PROJECT NUMBER 1003014 – SALAZAR FAMILY TRUST

CITY OF ALBUQUERQUE
PLANNING DEPARTMENT
DEVELOPMENT REVIEW BOARD

October 29, 2003

Project # 1003014
03DRB-01679 Major-Bulk Land Variance
03DRB-01680 Minor-Prelim&Final Plat Approval

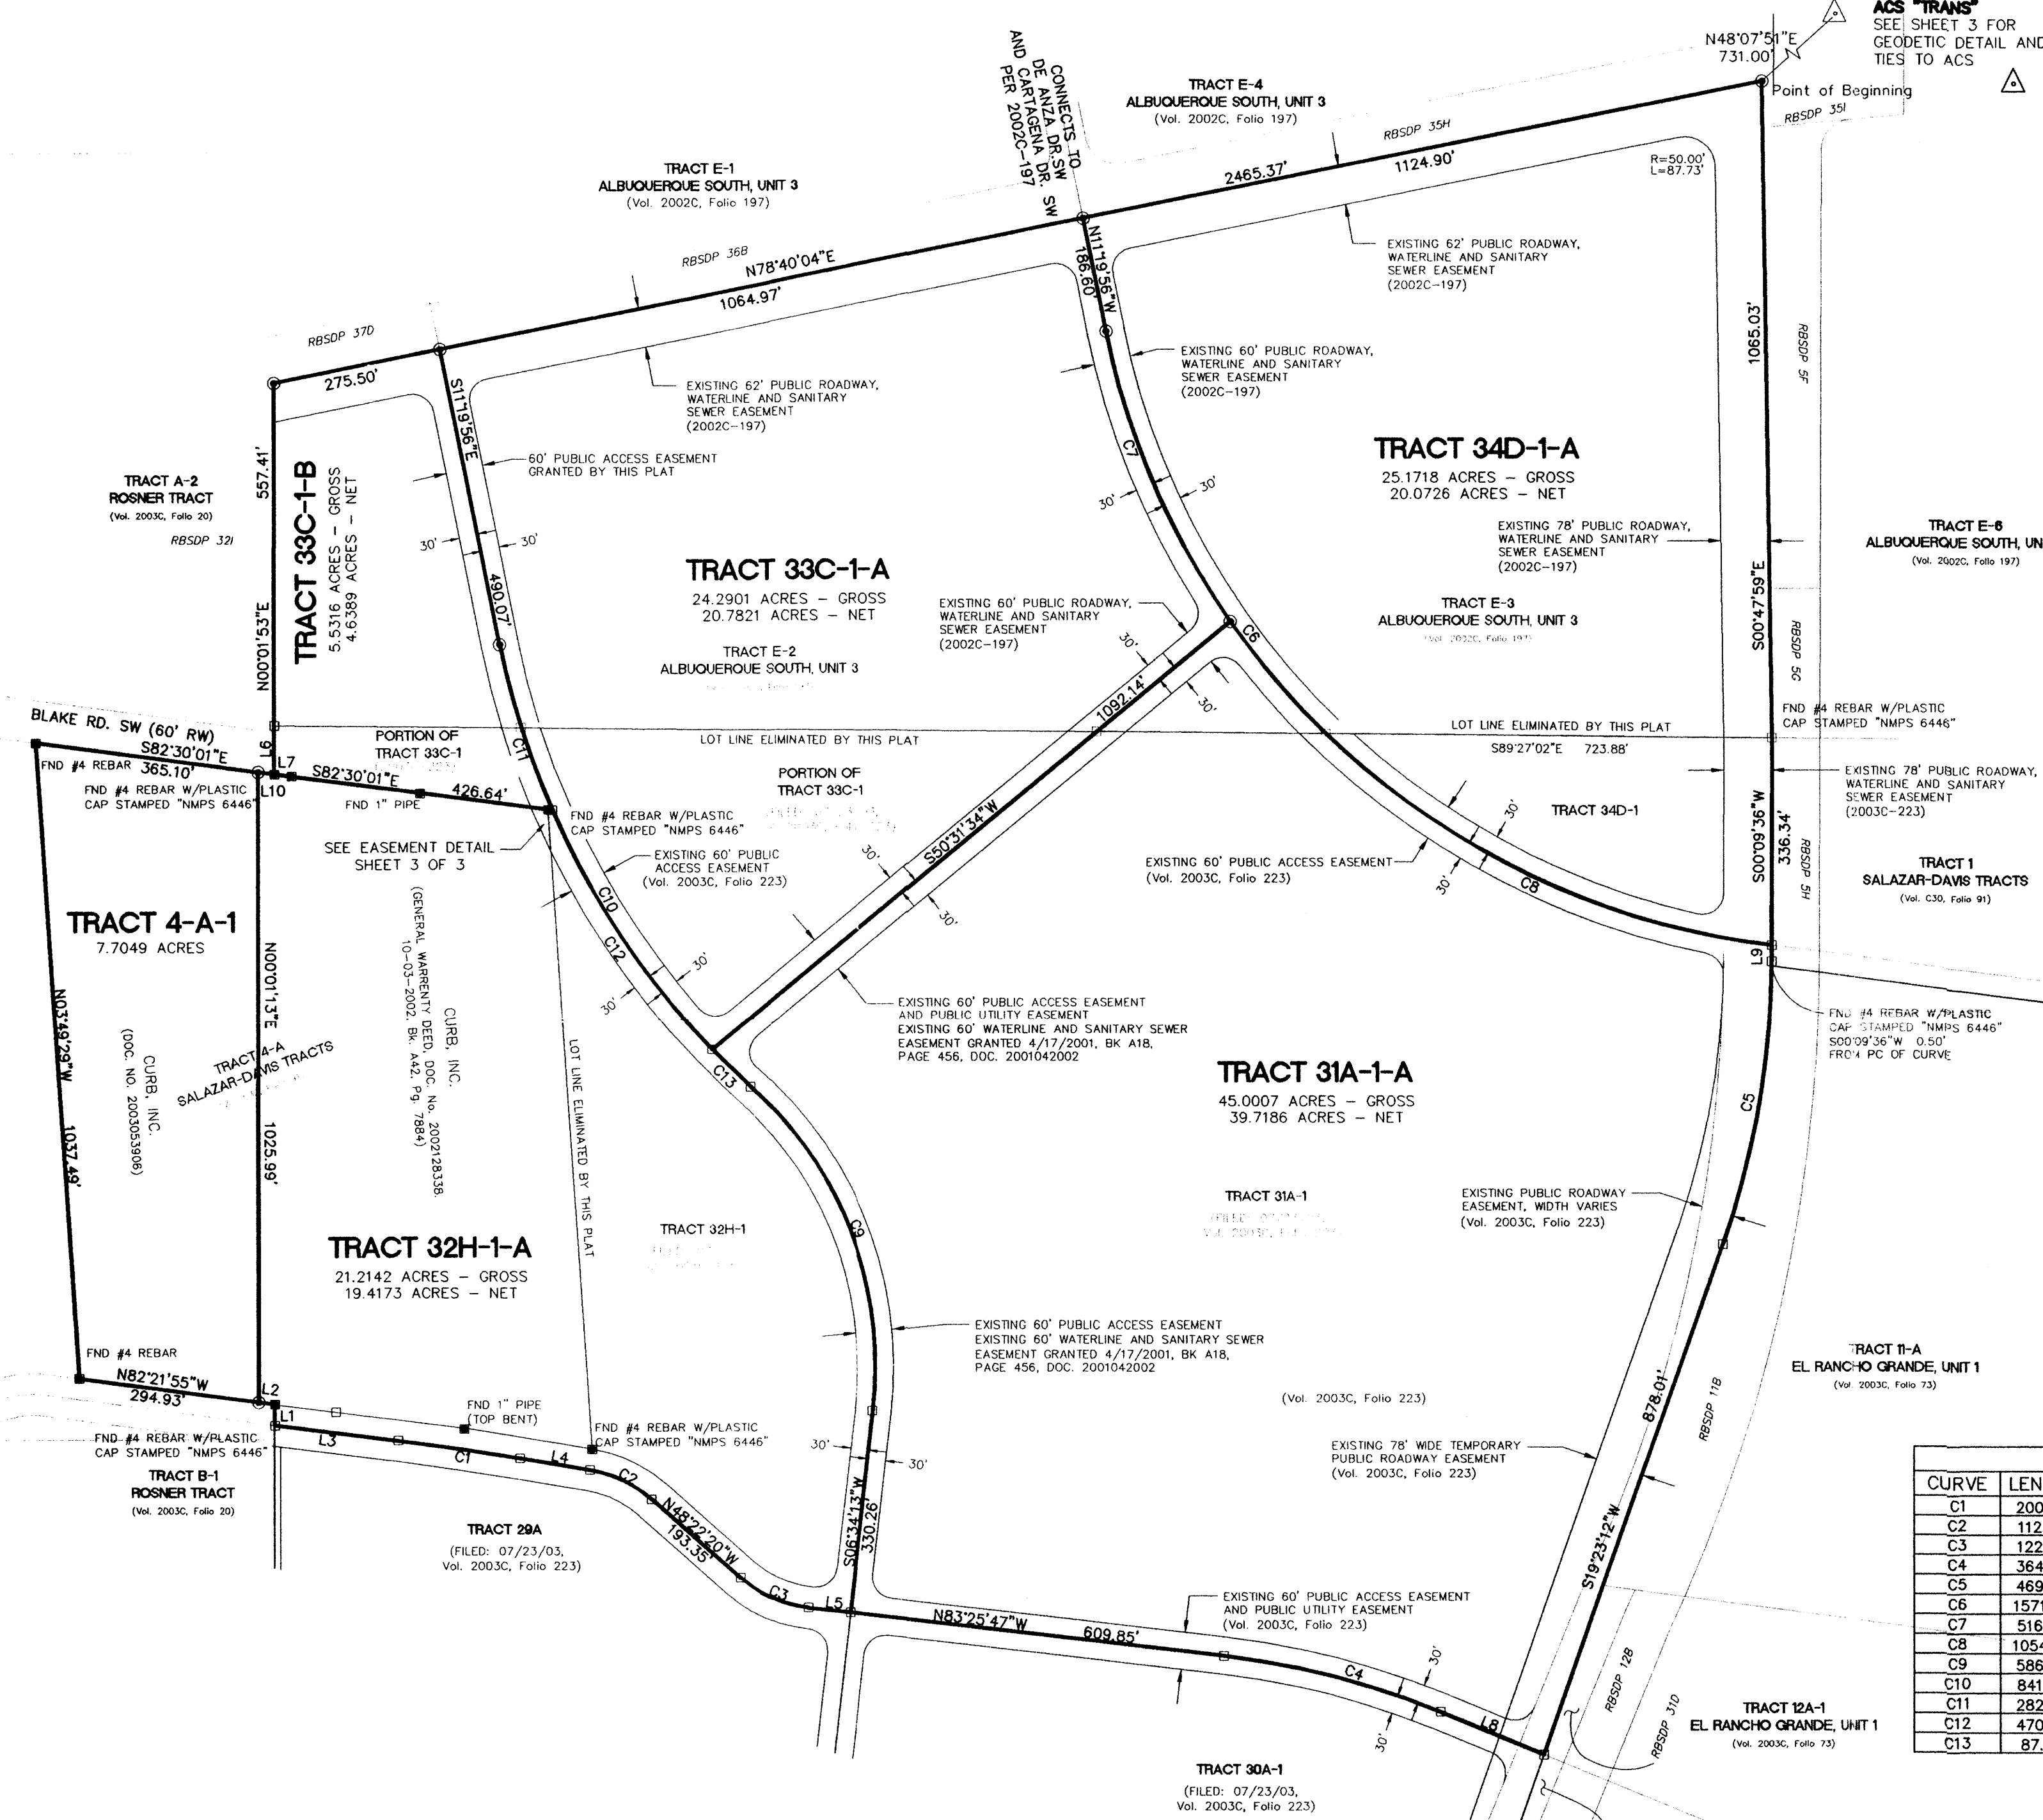
Provide documentation with regard to 124-foot of right-of-way versus 156-foot for Gibson. How does Tract 4-A-1 take access. Existing Blake Road north of Tract 4-A-1?
